Address/Location of Construction: 26 Wordsworth Street		
Total Square Footage of Proposed Structure:		Altered 570sqft
Tax Assessor's Chart, Block & Lot Chart# Block# Lot# 427 B 010	Applicant Name: Stephen Bassett Address 53 New Gloucester Rd City, State & Zip Durham, ME 04222	Telephone: 207-212-9105 Email: sbassett9105@gmail.com
Lessee/Owner Name: Katie Kondrat (if different than applicant) Address: 26 Wordsworth St City, State & Zip: Portland, ME 04101 Telephone E-mail:	Contractor Name: (if different from Applicant) Address: City, State & Zip: Telephone E-mail:	Cost Of Work: \$49,900 C of O Fee: \$ Historic Rev \$ Total Fees : \$ 5764.00
Current use (i.e. single family) <u>Single Family</u> If vacant, what was the previous use? _____ Proposed Specific use: <u>same</u> Is property part of a subdivision? _____ If yes, please name _____ Project description: <u>2nd floor remodel with dormers new stair cases.</u>

Job No: 26 Wordsworth Street
BP#2014-02176

ONE AND TWO FAMILY	PLAN REVIEW	CHECKLIST
Soil type/Presumptive Load Value (Table R401.4.1) _____		
Component	Submitted Plan	Findings/Revisions/Dates
STRUCTURAL		
Footing Dimensions/Depth (Table R403.1 & R403.1(1), (Section R403.1 &

STAIR DETAIL

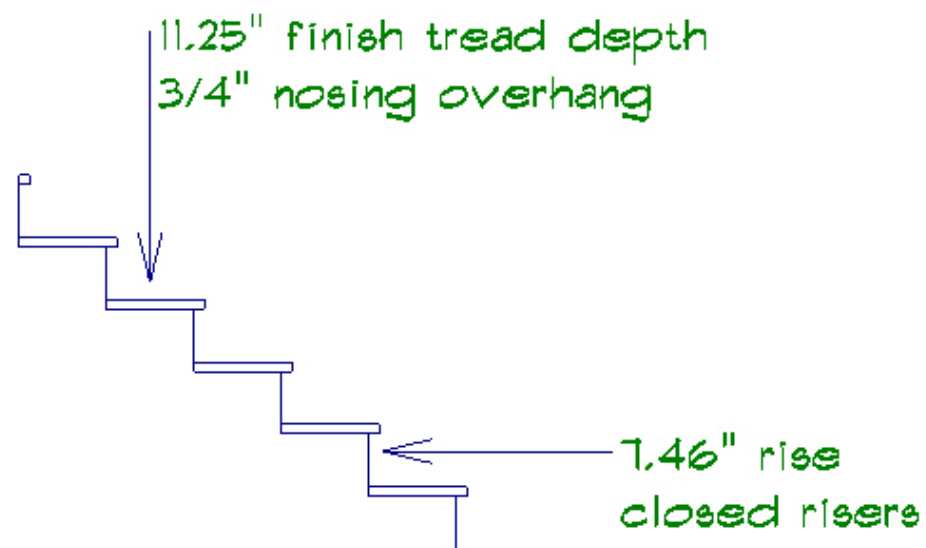
Type of Heating System		
Means of Egress (Sec R311 & R312) Basement Number of Stairways Interior Exterior Treads and Risers (Section R311.5.3) Width (Section R311.5.1) Headroom (Section R311.7.2) Guardrails and Handrails (Section R312 & R311.5.6 – R311.5.6.3)	<p>OK</p> <p>NA</p> <p>OK per plans</p> <p>Requested width of stairway.</p> <p>Requested headroom for stairway.</p> <p>Requested details for handrails for new stairway.</p>	<p>OK per revised plans.</p> <p>OK per revised plans.</p> <p>OK per revised plans.</p>
Carbon Monoxide Alarms (R315) Smoke Alarms (Section R314) Location and Interconnected	<p>Requested smokes and CO alarms.</p>	<p>OK per revised plans.</p>
Dwelling Unit Separation (Section R302.3)	<p>NA</p>	
Deck Construction (Section R502.2)	<p>NA</p>
